Your Ref: OWPC16595
Our Ref: BR/280/17/PL 10-10-2017
Please ask for:
Richard Temple

1 No. dwelling. This application may affect the setting of Listed Buildings & affects the character & appearance of the Upper Bognor Road & Mead Lane Conservation Area.

Land adjacent to 8 Mead Court Mead Lane Bognor Regis

Front Elevation

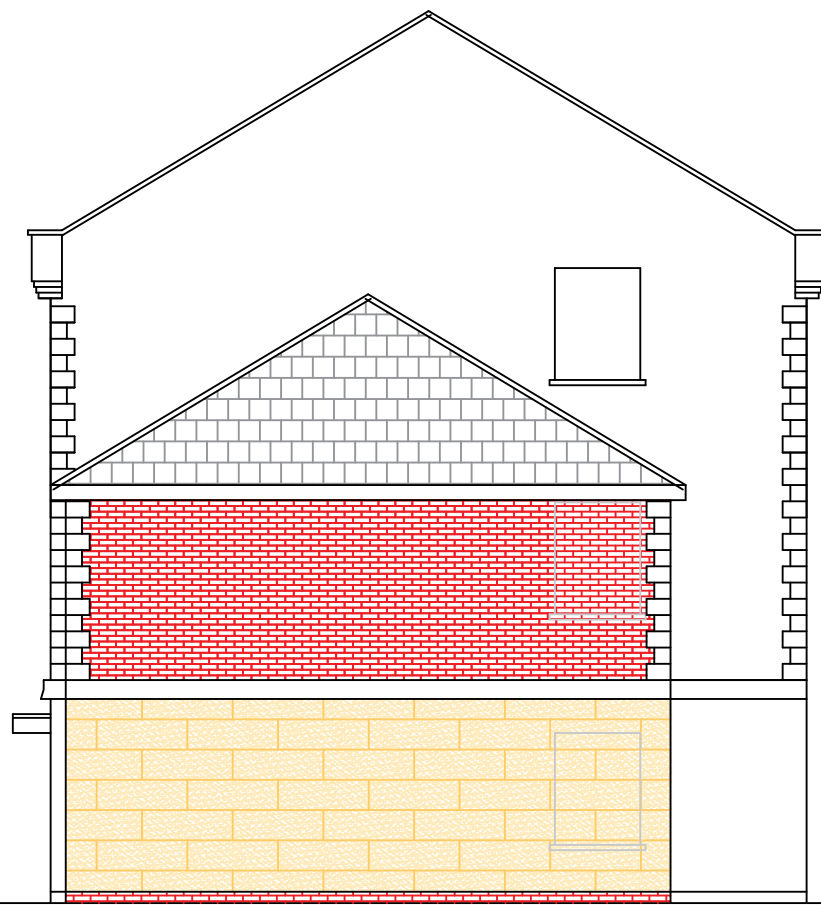
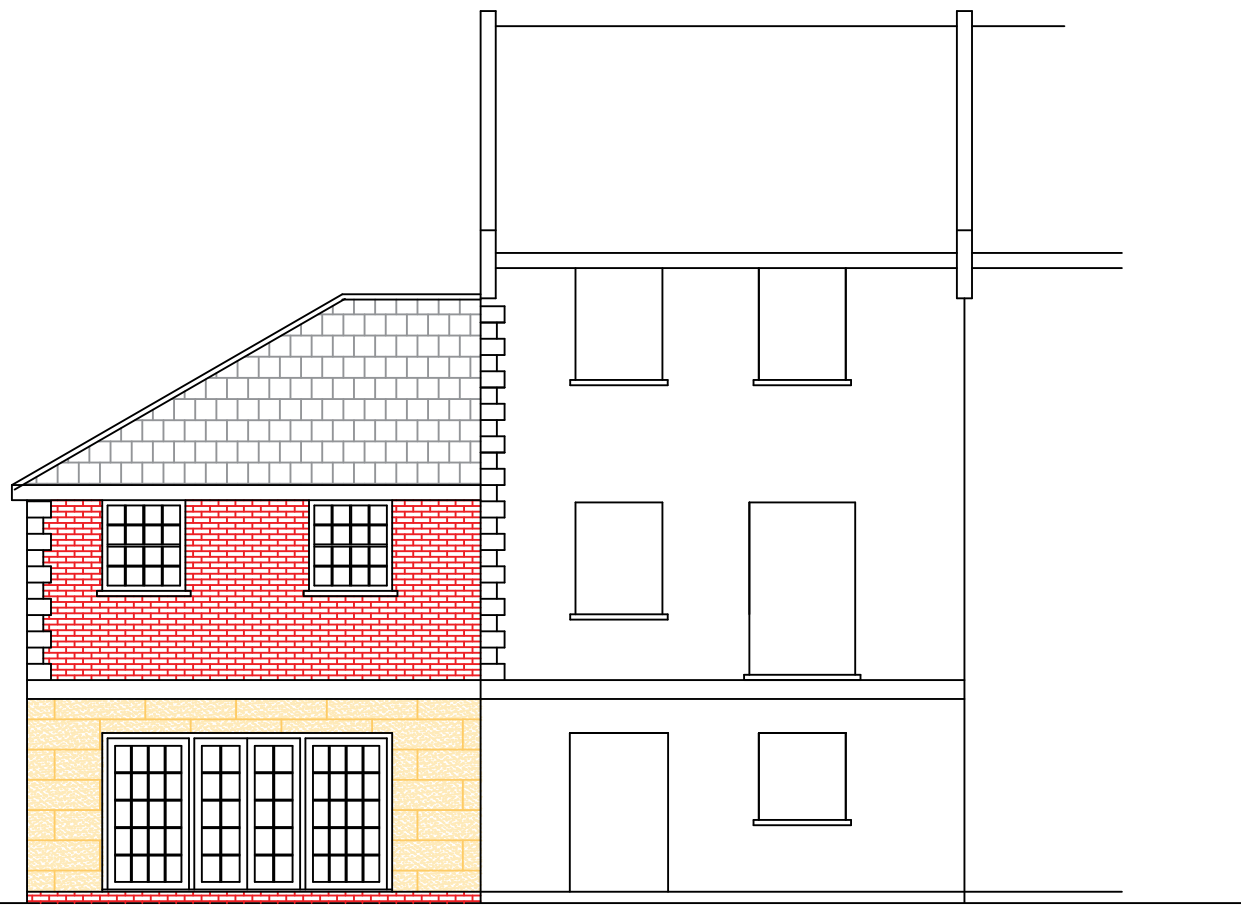
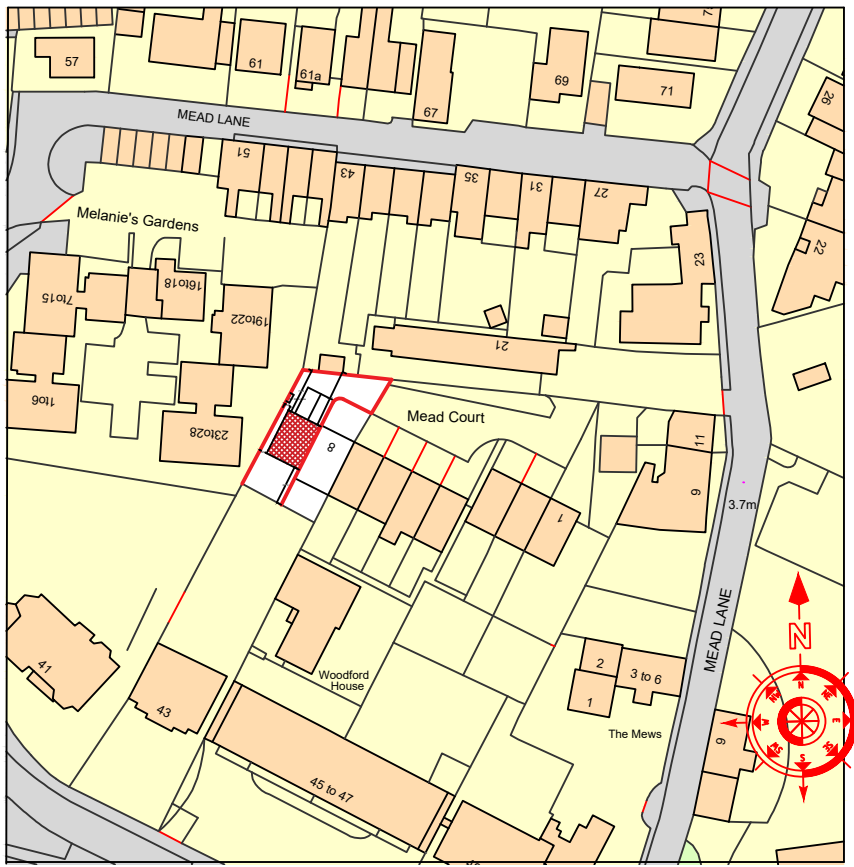
- 4. Situated as a squat 2-storey addition at the western end of a row of well-designed 3-storey terraced town houses it would throw the aesthetic equilibrium of the whole 8 terraced building out of kilter. It would make it look asymmetric by adding a building to one end of the terrace without a matching one at the other end making the whole terrace look lopsided. It certainly would not "blend" in as the Design Statement suggests. It would stick out like a sore thumb. The fact it was at a different height would draw the eye towards it and highlight it.*

- 8. The existing 8-row terrace is a good modern design and this insensitive extension is hostile and alien to the original design concept of the existing building. It looks odd and ill-fitting from the front elevation, the side elevation, and the rear elevation.*
